Our Ref : 0010/13/MA1
Date : 21st December 2015

**Re : Minor Amendments to Regeneration of Hoyland Town Centre Planning Application
reference no : 2015/0711**

Drawing no: 0010.13.02 143 Rev: E

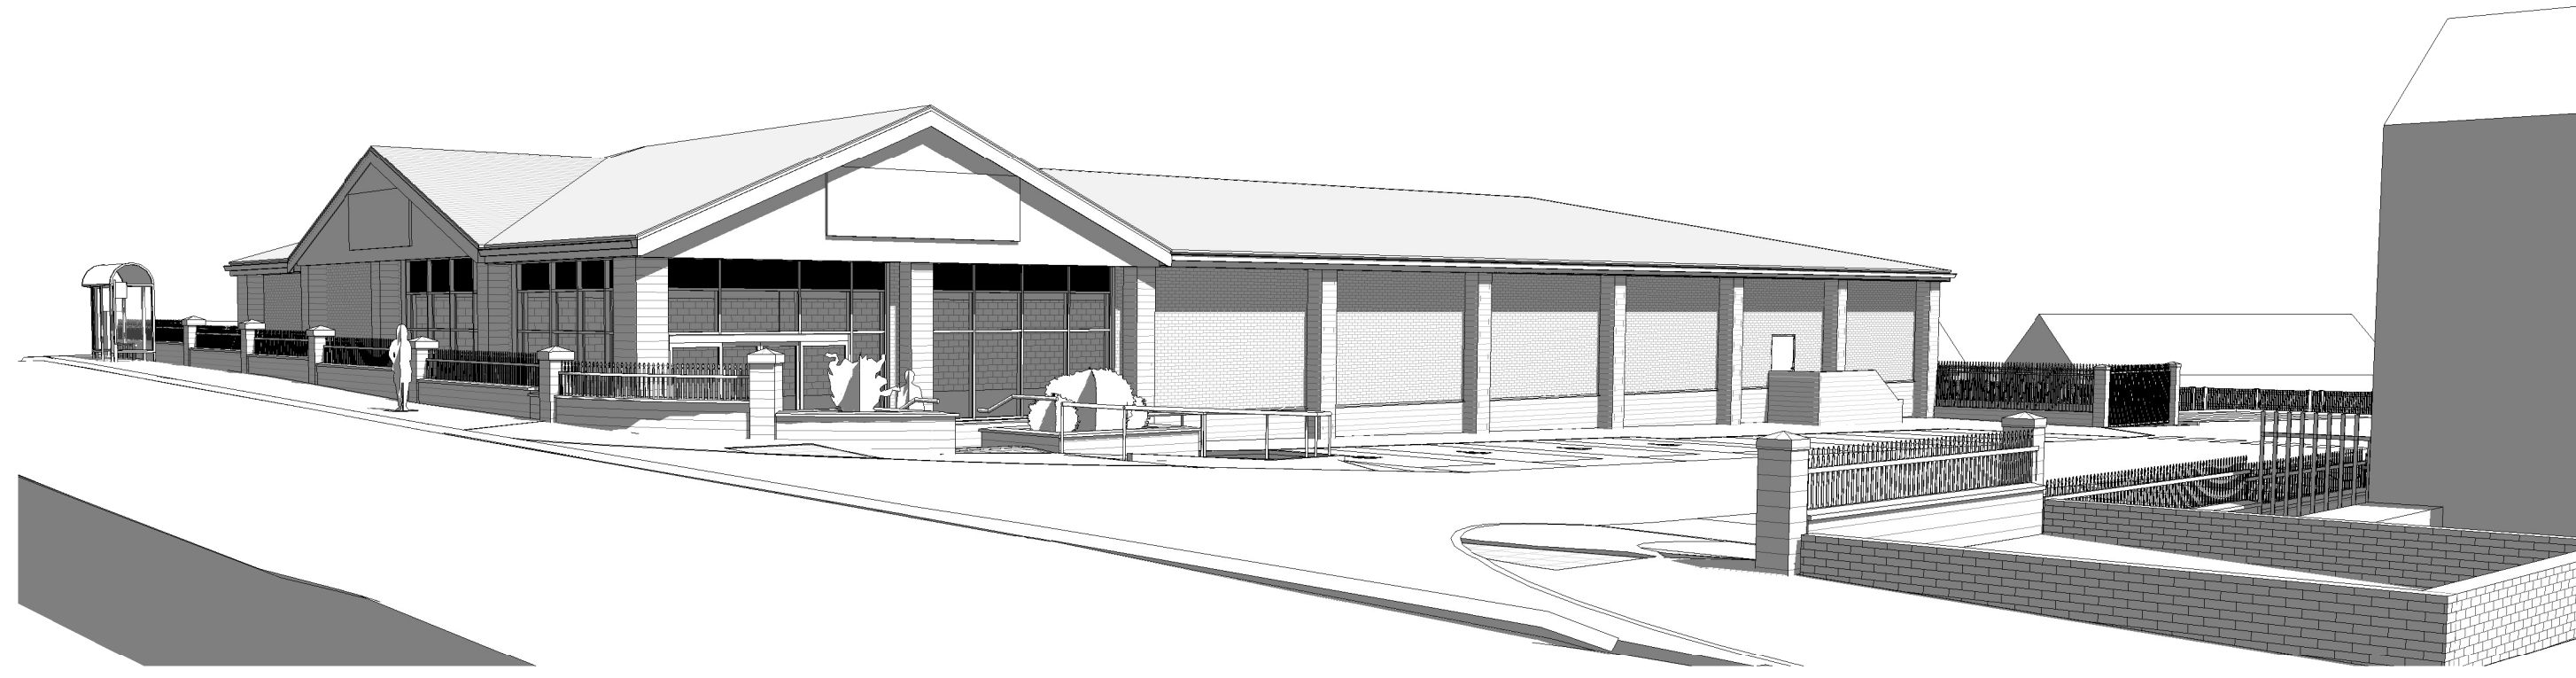
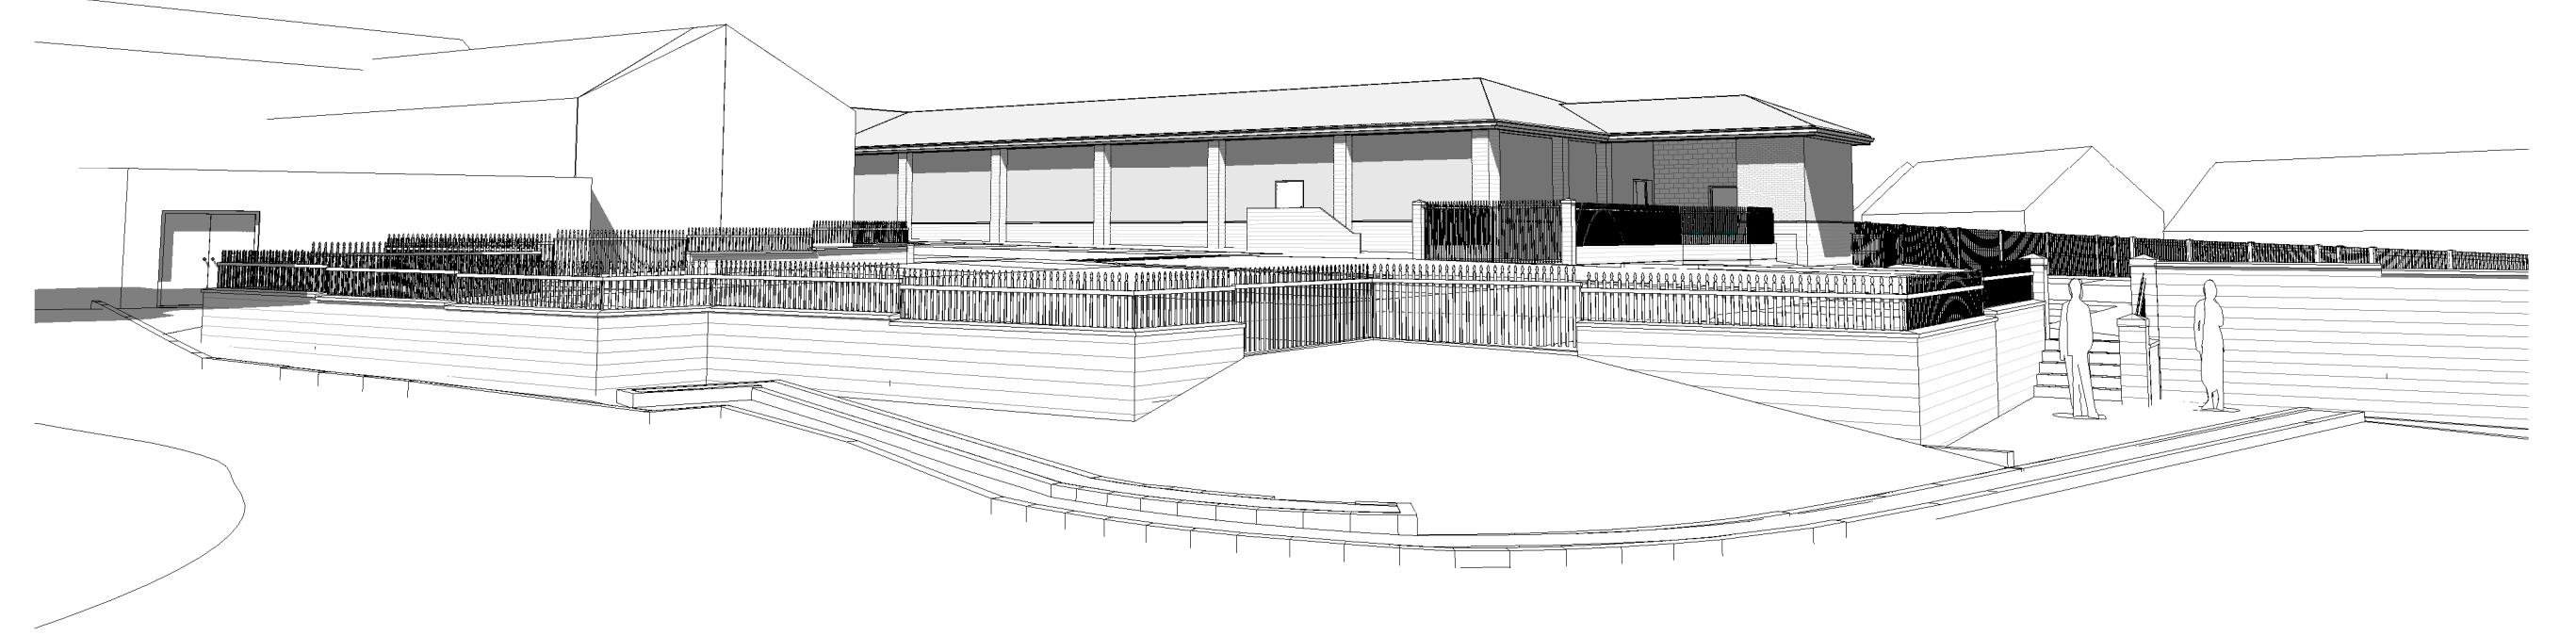
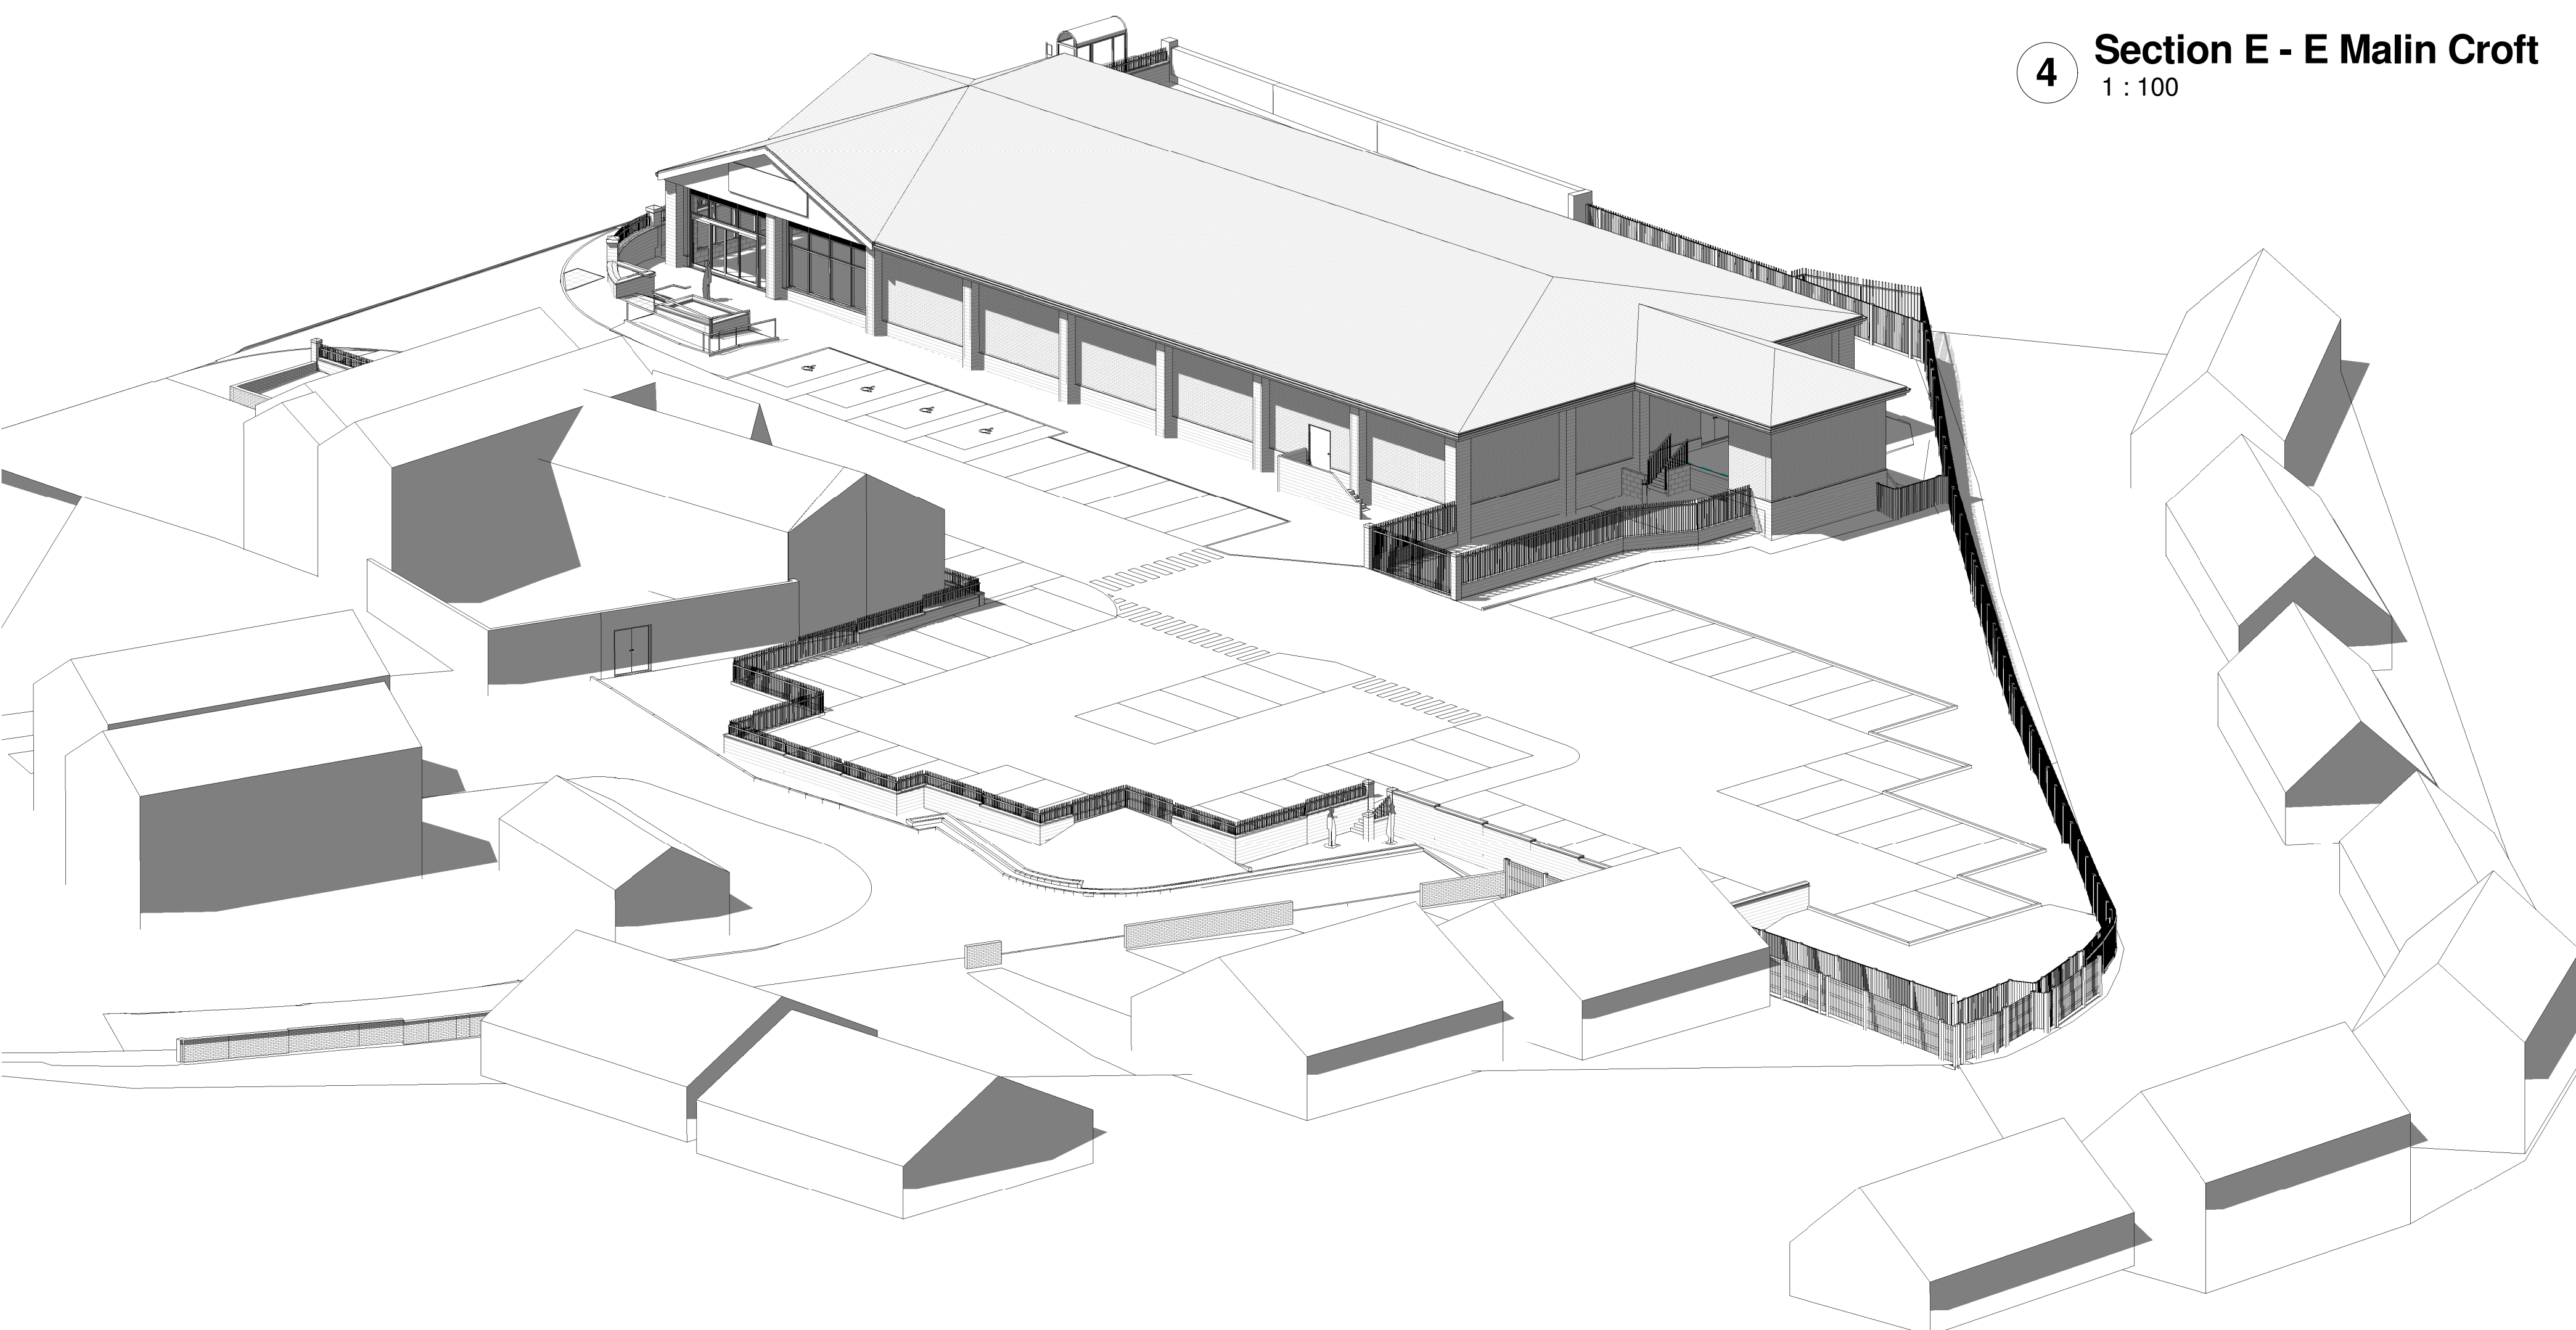
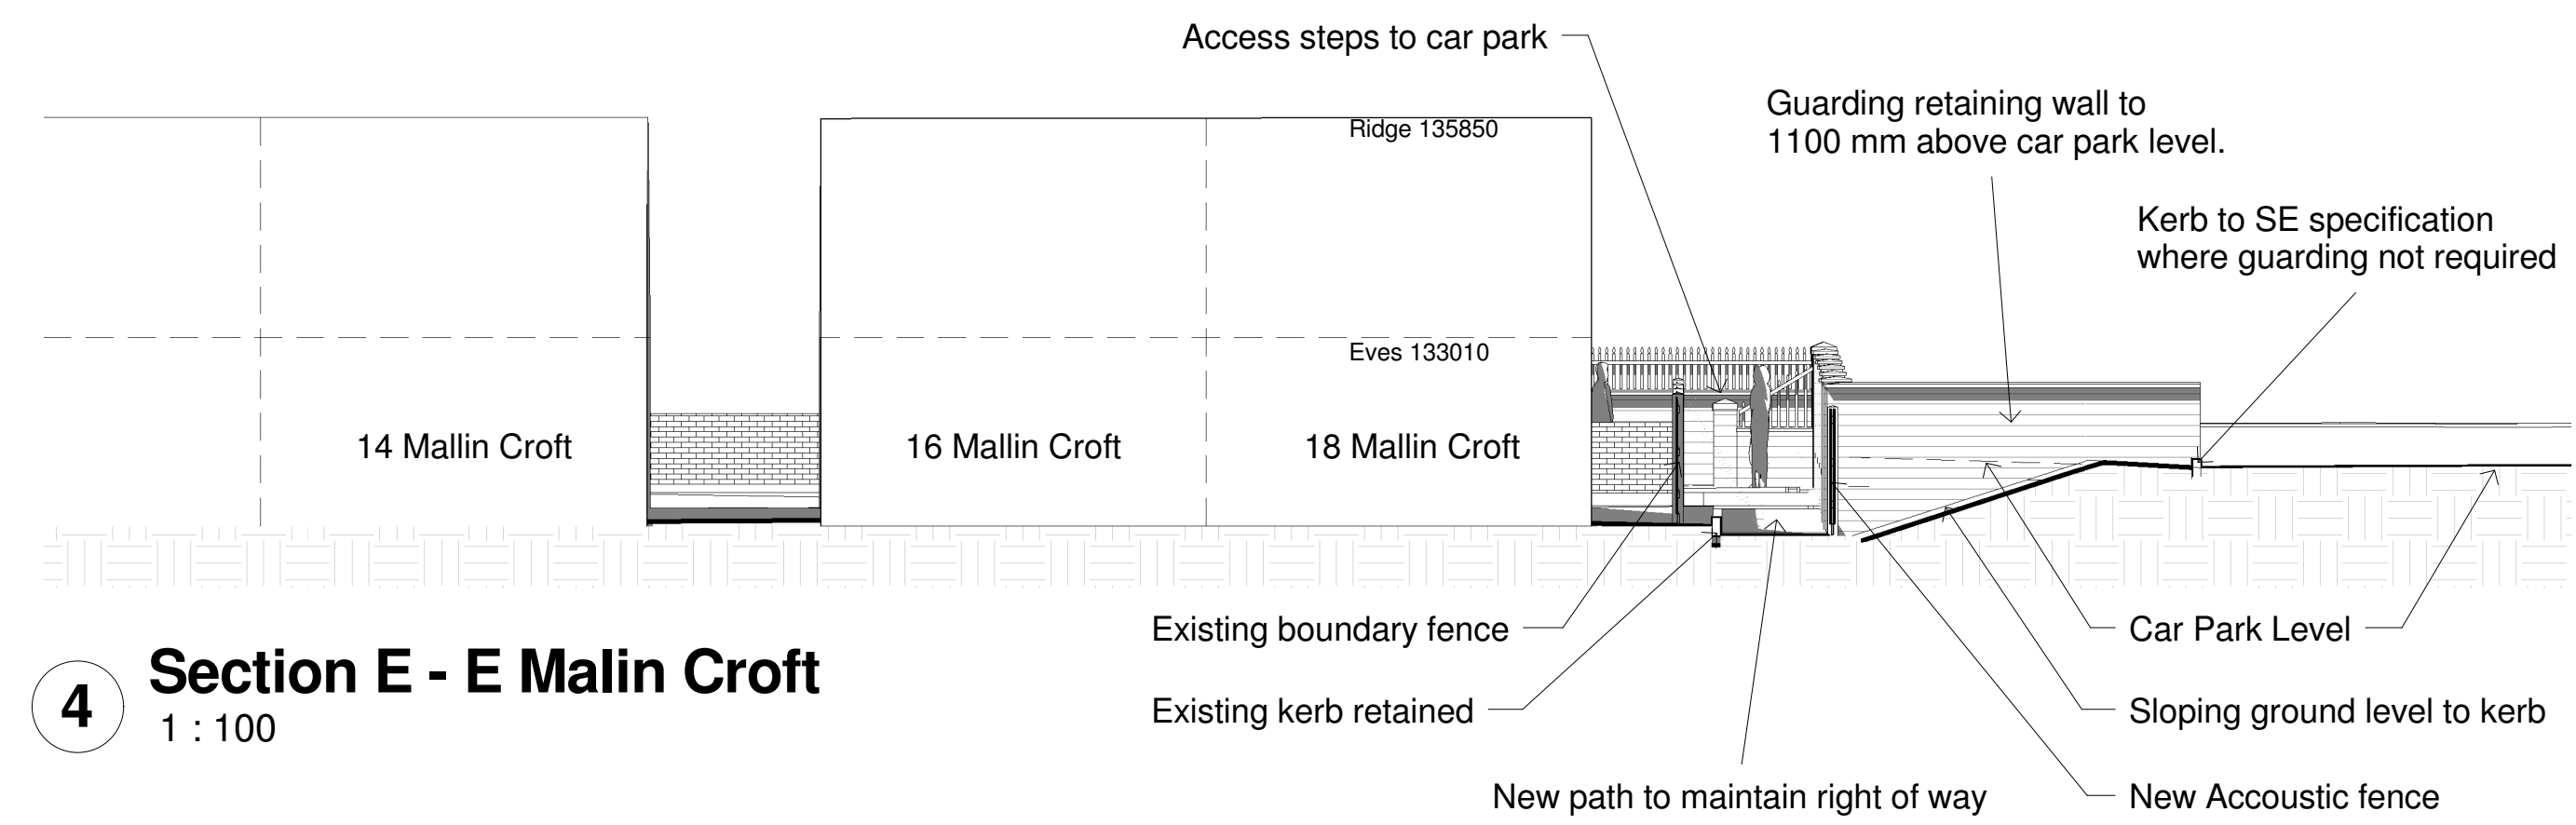
- i) Amendment to the shop front and entrance
- ii) Amendment to roof covering from natural slate to slate effect covering
- iii) Amendment to roof pitch and consequential reduction to the ridge height
